# SCH STAGE 1 / CCCC

## PUBLIC DOMAIN & LANDSCAPE

### RESPONSE TO SUBMISSIONS REPORT

SSD-10831778  
14 September 2021  
APPENDIX No. 01

DRAWING
GENERAL ARRANGEMENT
PLAN L06

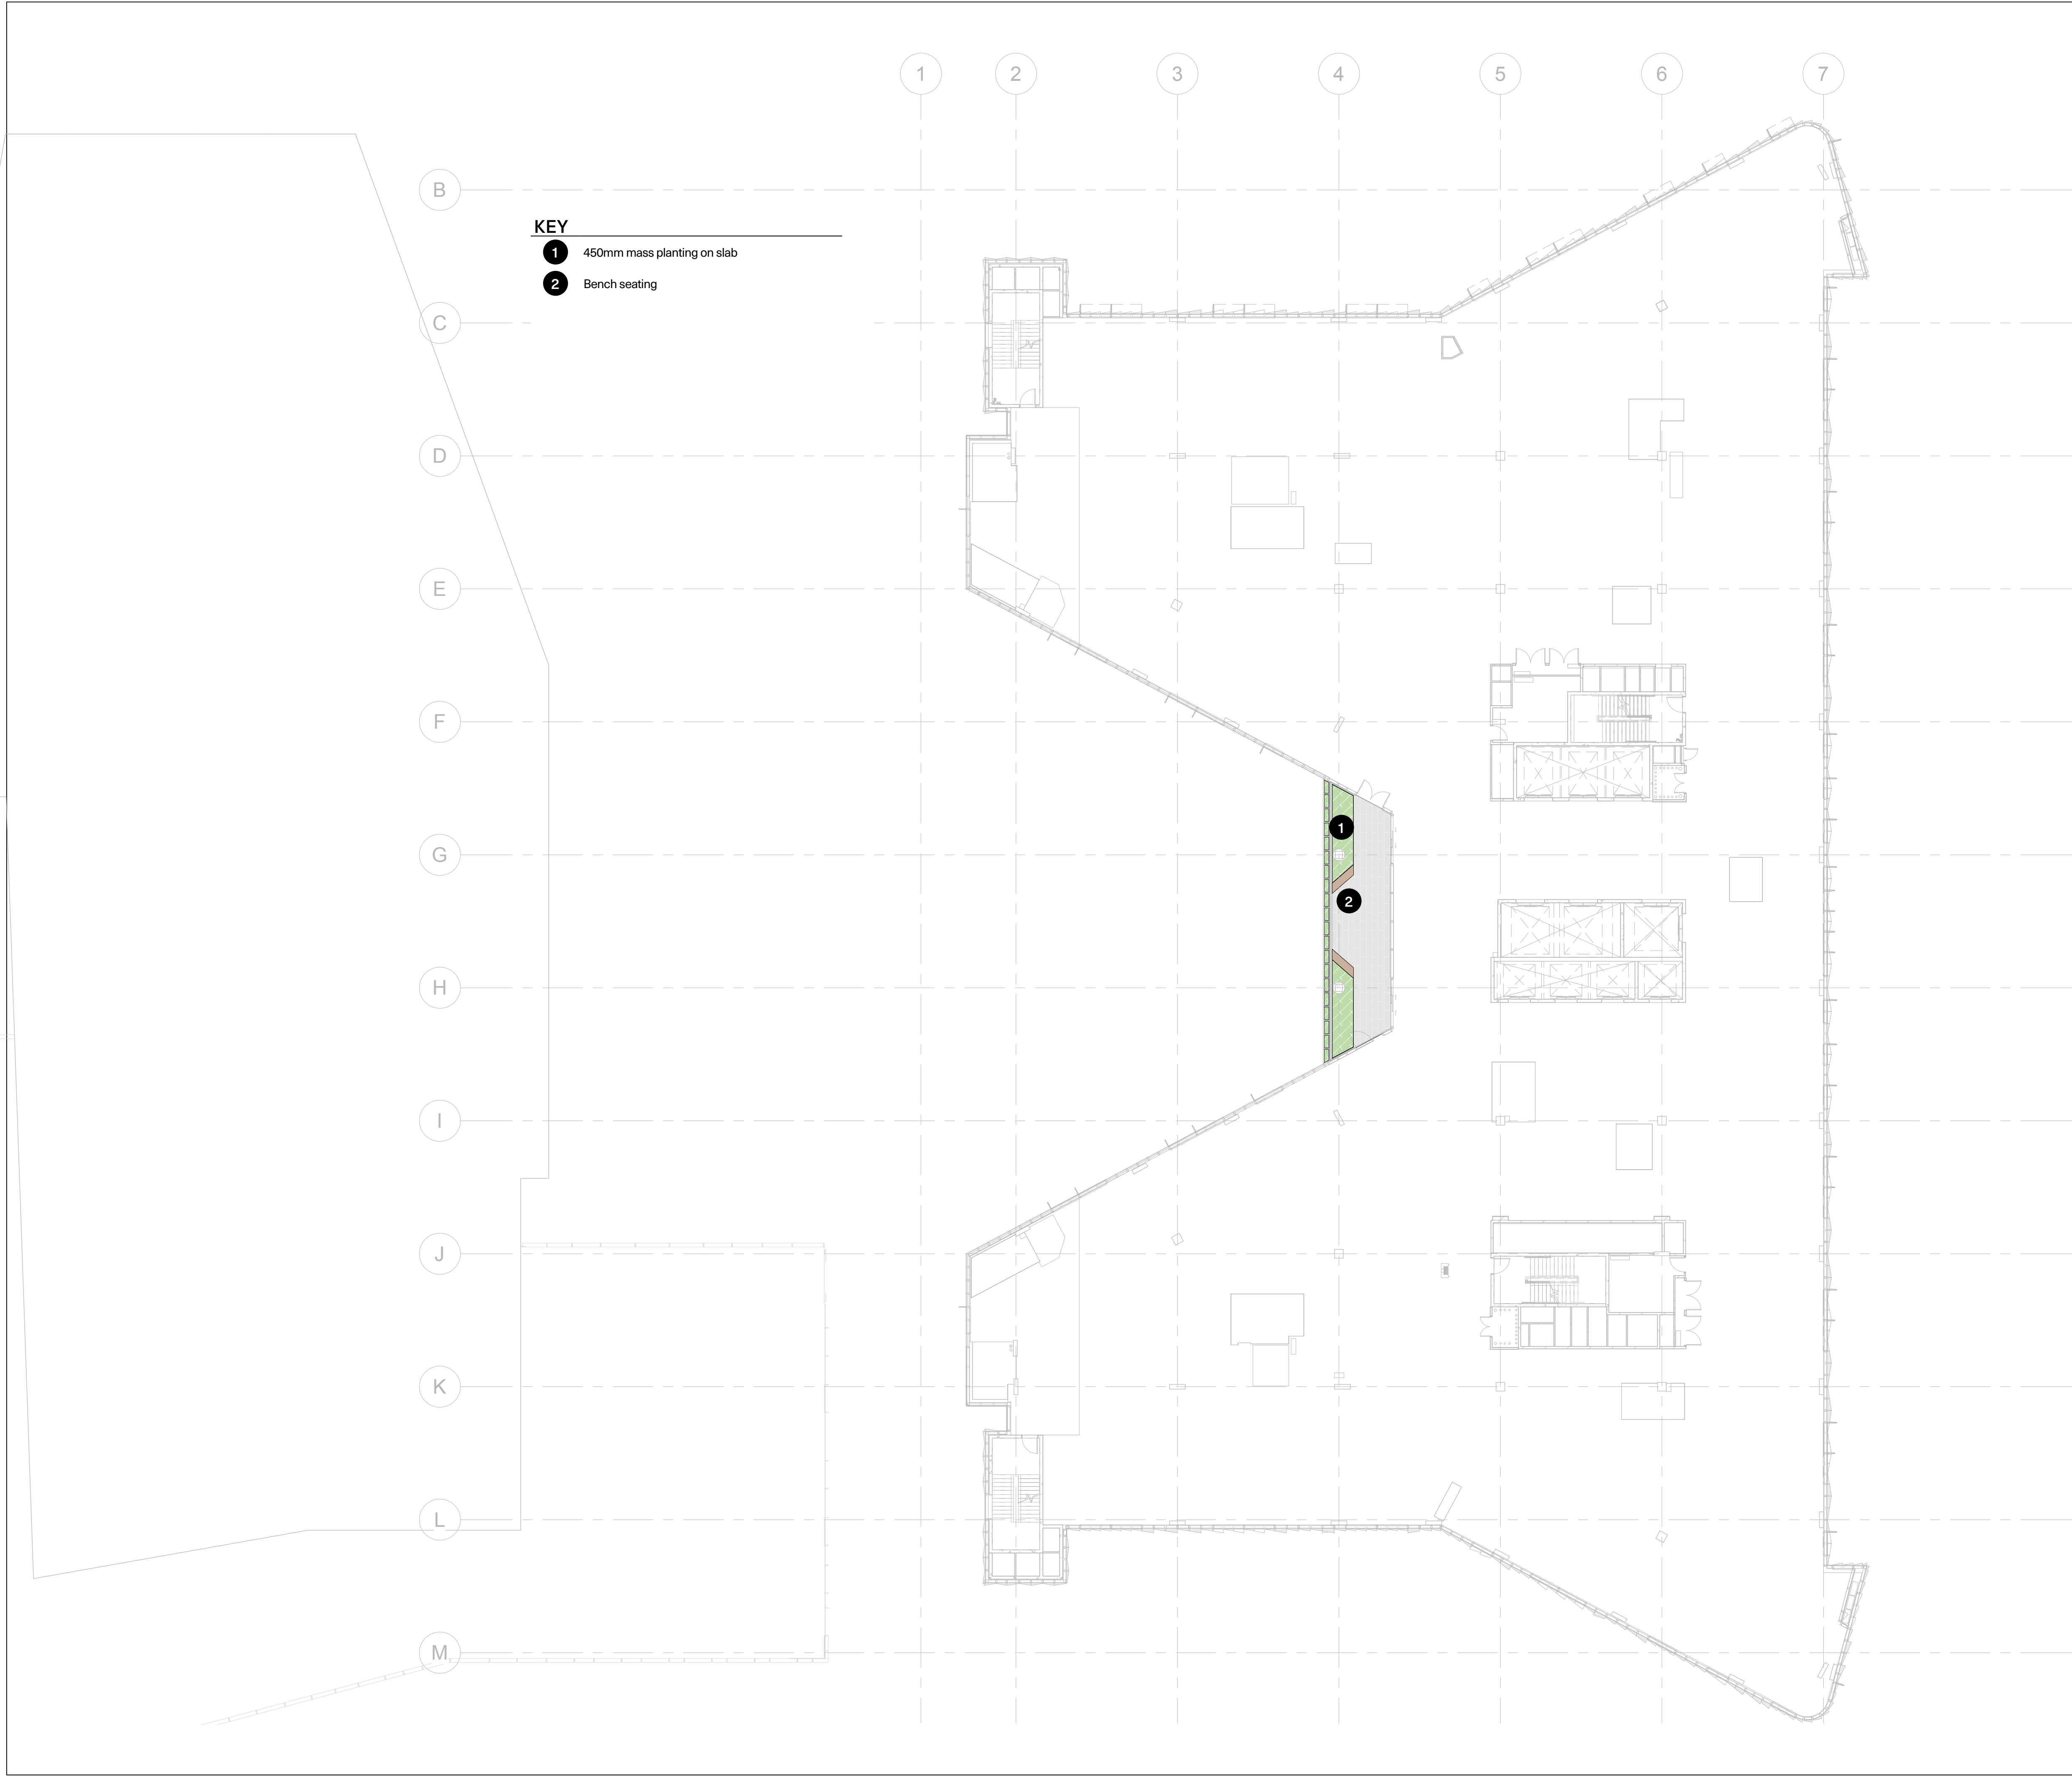
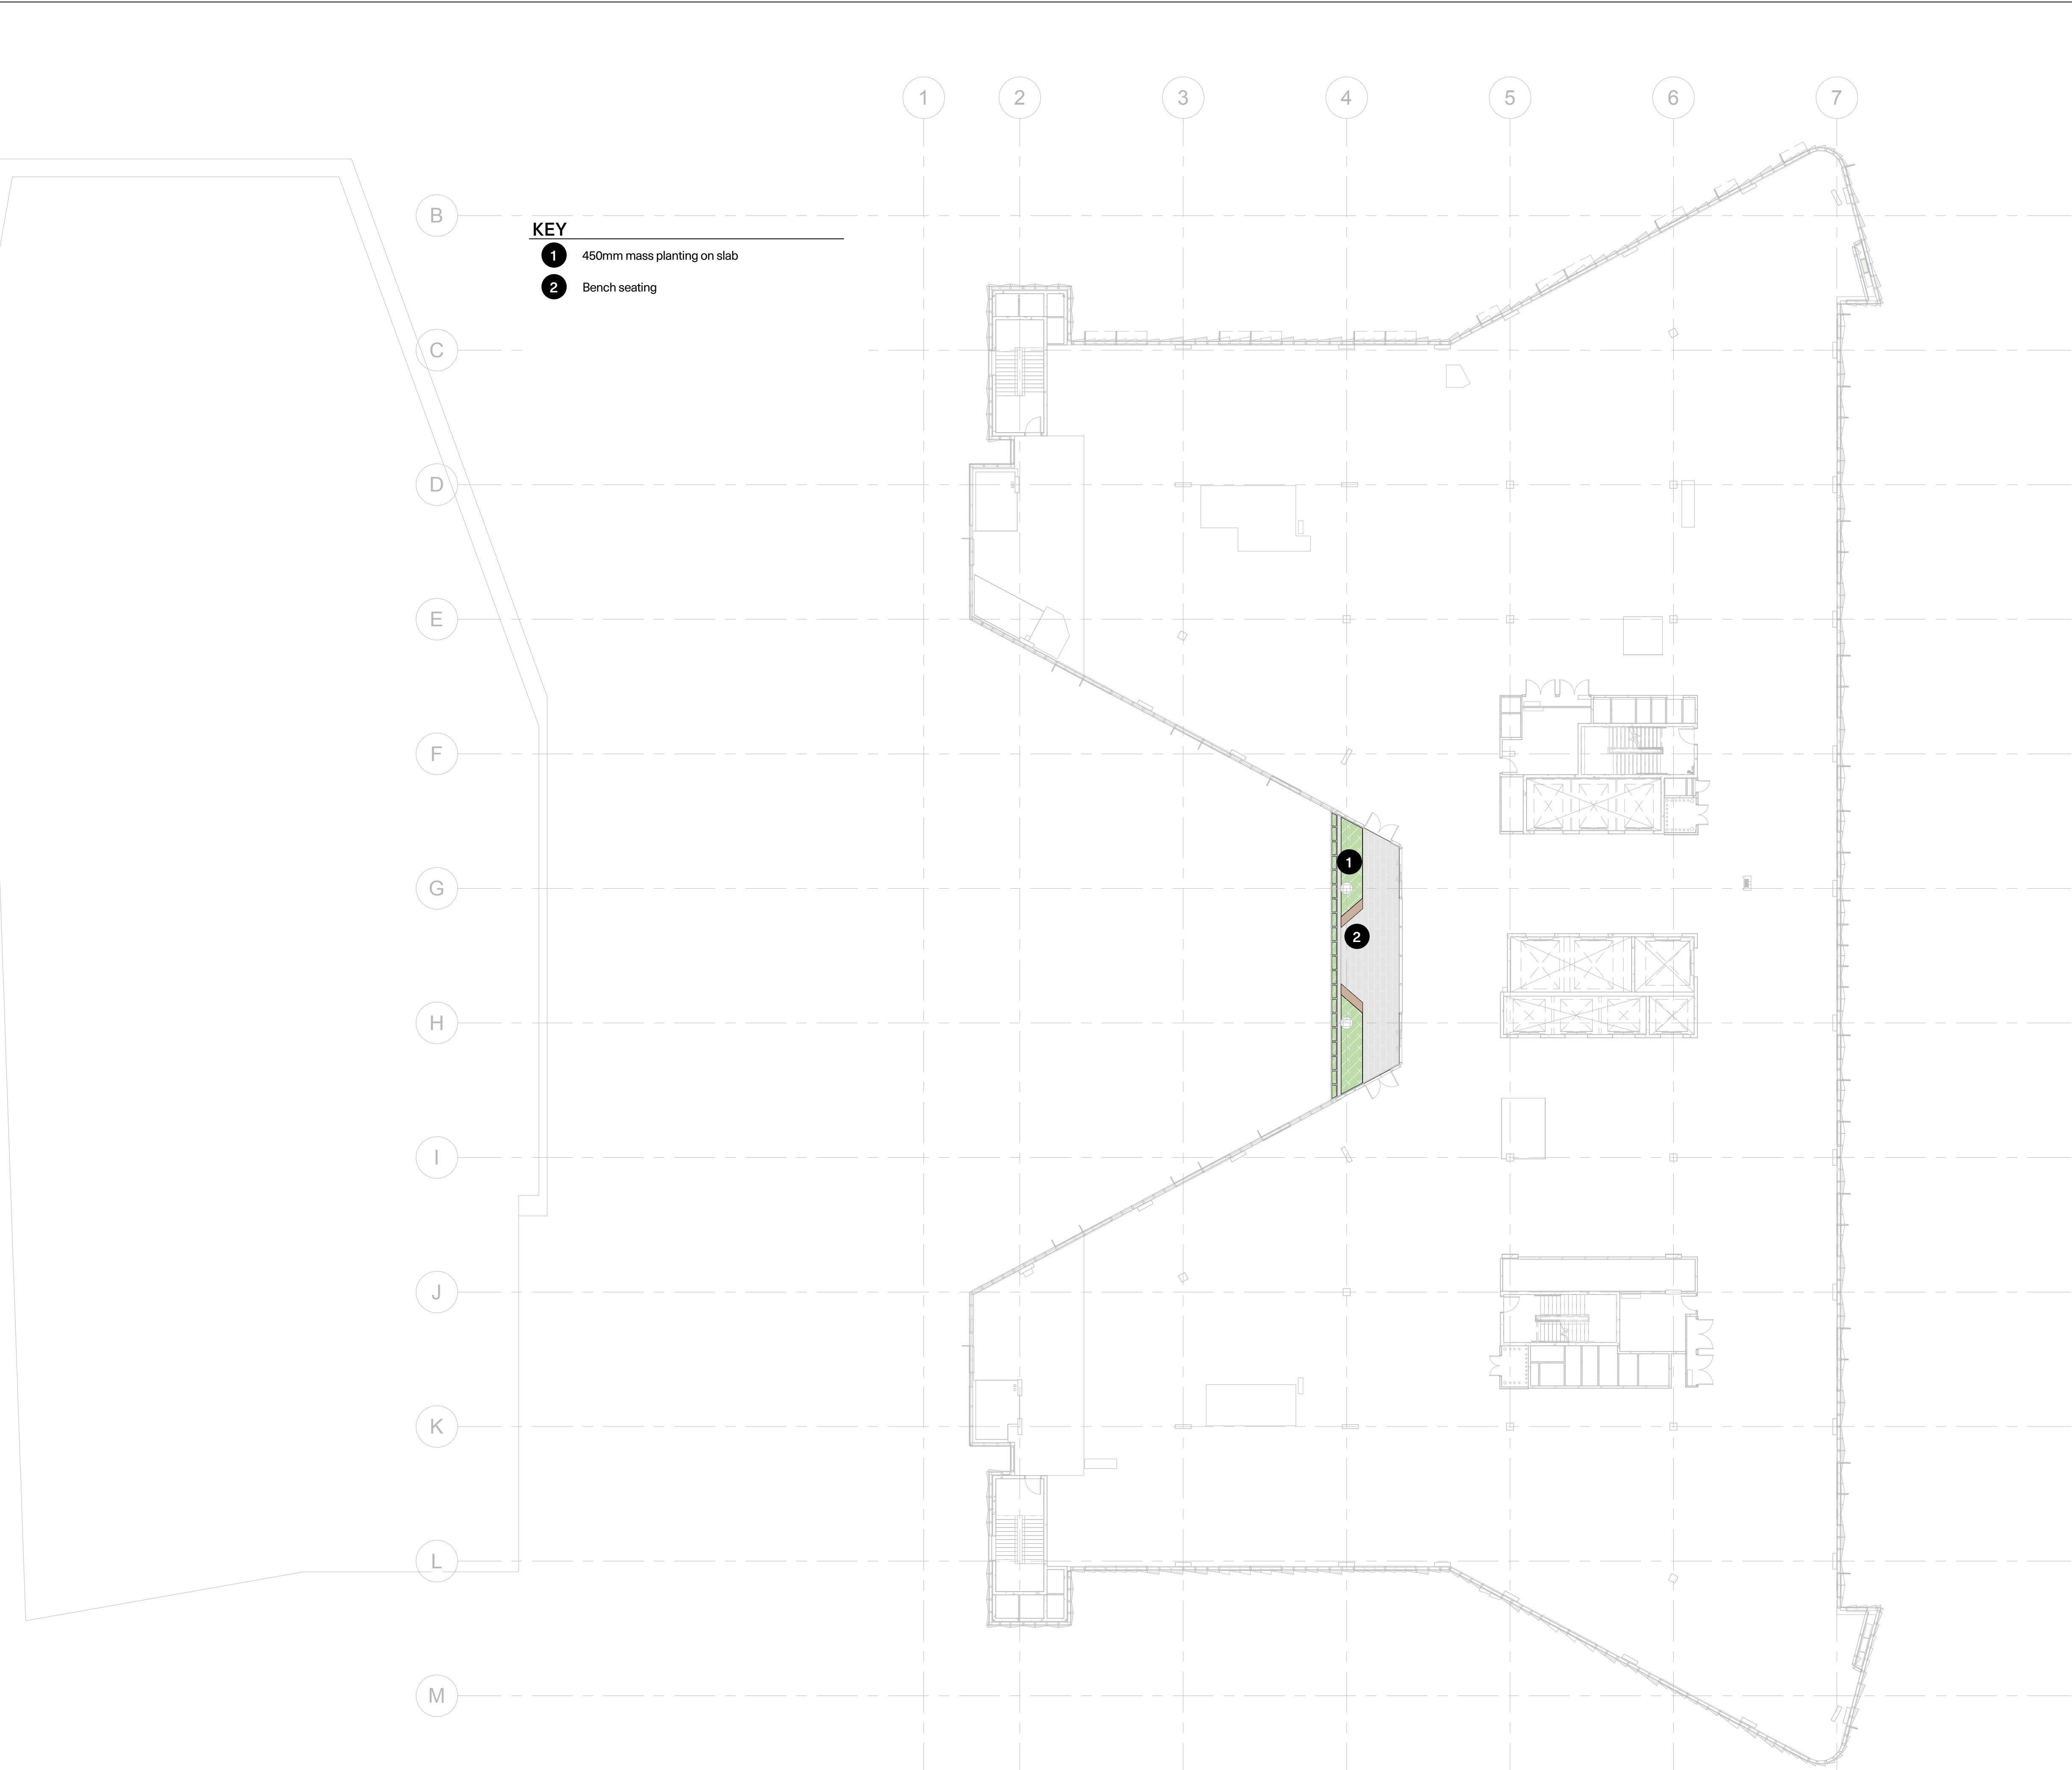
Visualisations indicate landscaping to upper levels terraces and utilisation of podium roof areas for landscaping but no details are provided on the landscape plans. Landscape plans should be updated to include these areas and demonstrate provision of high quality outdoor spaces for occupants of the building and to assist with offsetting any shortfall in tree canopy cover.

Further landscape detail is required for the proposed roof level and upper level terraces as the building form steps back. The podium roof areas should be utilised to provide outdoor landscaped terraces areas for patients, visitors and workers where possible.

The design team has included additional reference to the upper level terraces for levels 1, 4, 5, 6, 7, & 8, including the landscape plans as part of the updated landscape drawings. These series of accessible and inaccessible landscape spaces provides opportunities for patients, staff and visitors to experience the biophilic benefits of being in contact with plants and natural systems on a day-to-day basis.

The design team has updated the outdoor terraces to illustrate extent and use of these spaces. This includes a series of accessible and inaccessible spaces that allow for patient, staff, and visitor respite, engagement and enjoyment and will be developed further during DD stage.

KEY	
	SCH1/CCCC trees
Site Area	9,868m2
Tree Canopy Coverage	1,534m2

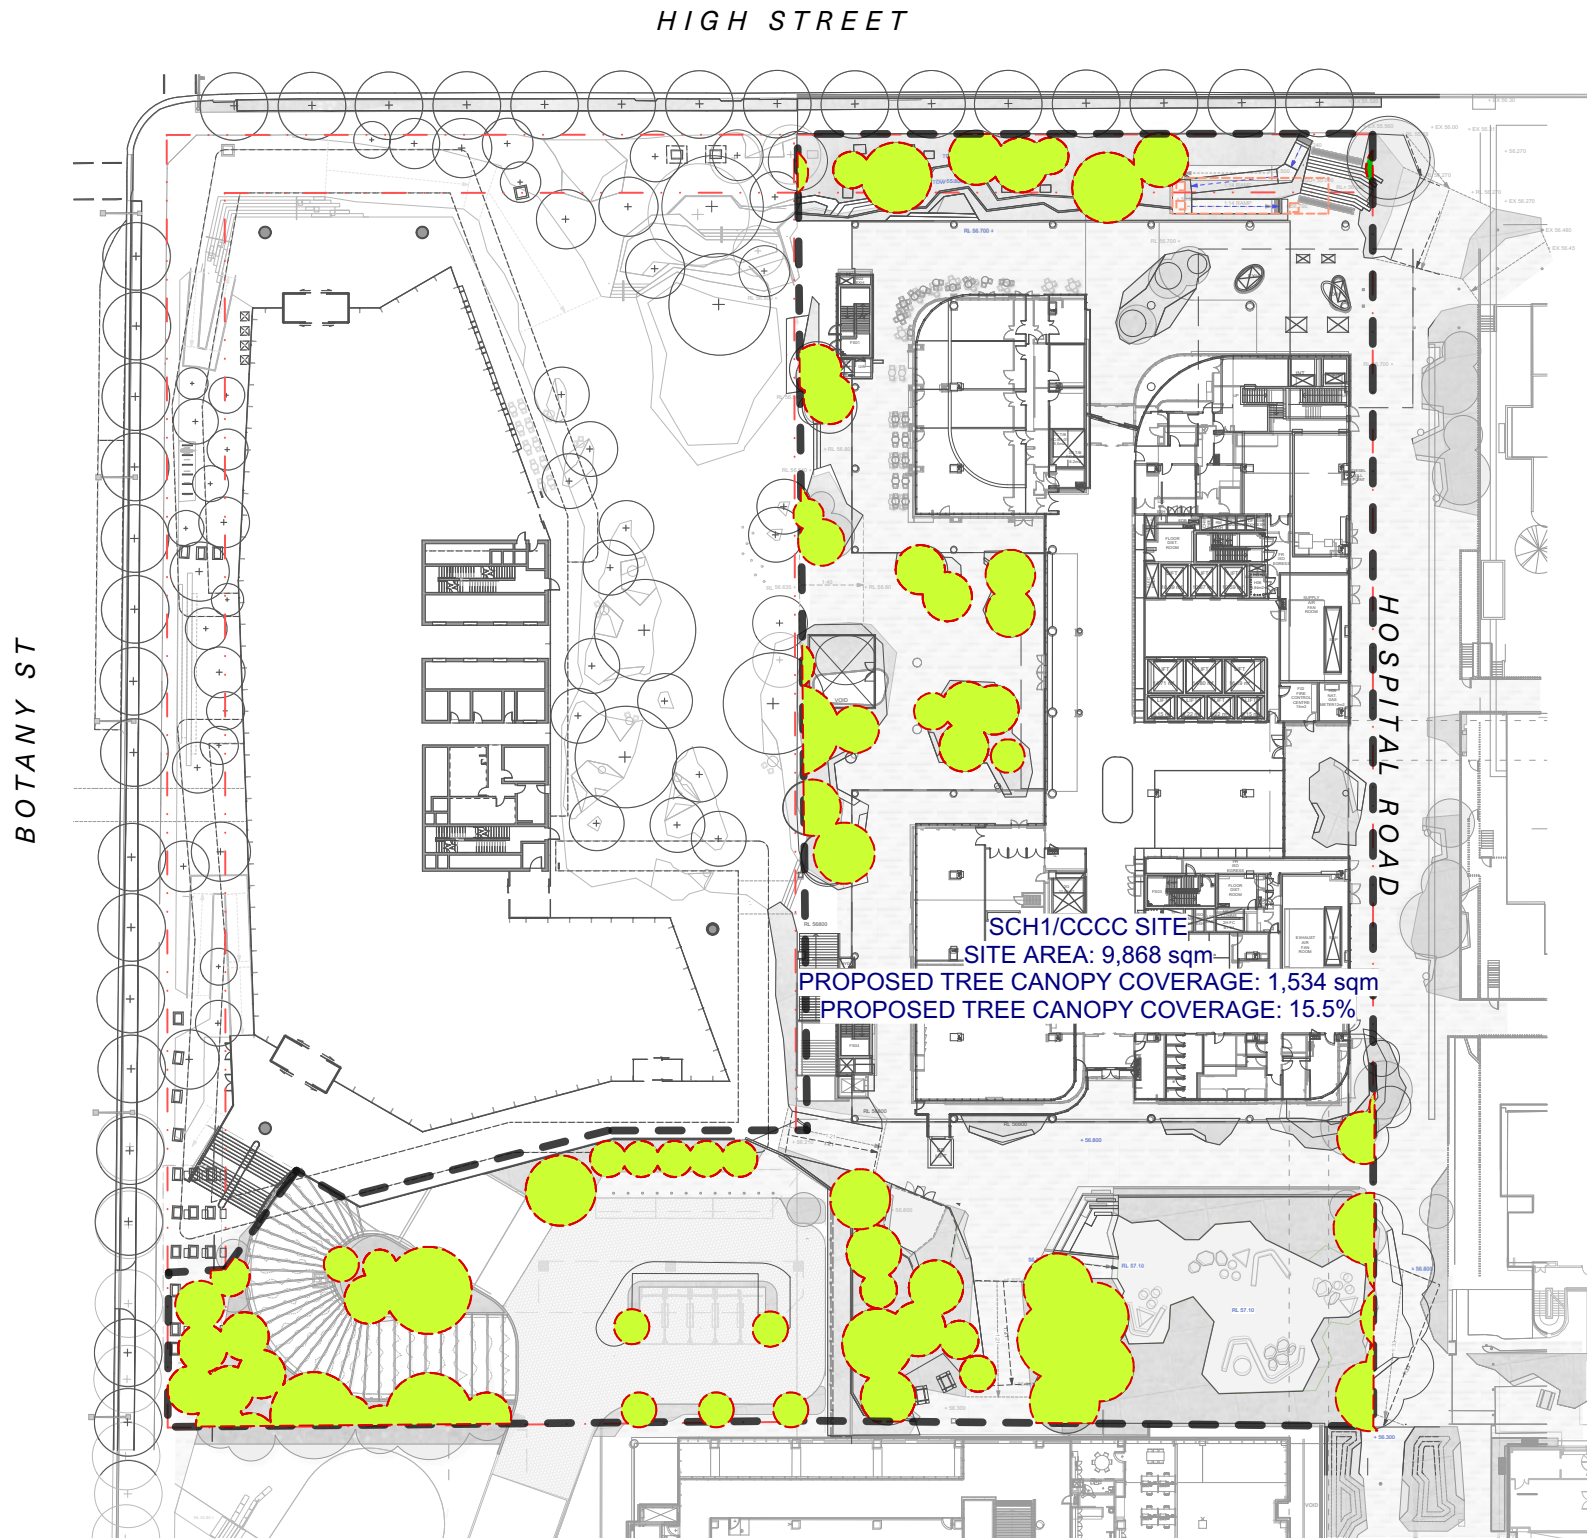
Consideration should be given to improving tree canopy cover, noting the proposal falls short of minimum 25 per cent recommended within the NSW Government Architect’s Draft Greener Places Design Guide. Any comparisons against the ‘existing’ canopy coverage to justify the proposed canopy cover should be based on an assessment of the canopy cover of the previous residential use of the site, prior to clearing of the site. Consideration should be given to opportunities to providing more or larger trees at the ground plane through improved soil depth and volumes for on-structure plantings and through more detailed consideration of opportunities and limitations of plantings above and around the stormwater culvert.

It is noted that the proposal includes a 15.5 percent site canopy cover. This canopy target is well below the minimum 25 percent tree canopy cover outlined in the Urban Tree Canopy Guide within the NSW Government Architect’s Draft Greener Places Design Guide. The Draft Design Guide is recommended for use by State and Local Governments and industry to increase tree canopy across Greater Sydney. The proposed site canopy cover should be increased.

The design team has undertaken a review of the tree calculation including increasing the tree canopy coverage. The site is constrained due to the building footprint and basement below, limiting the ability to increase tree canopy coverage whilst maintaining pedestrian paths, clear and intuitive wayfinding, and building egress.
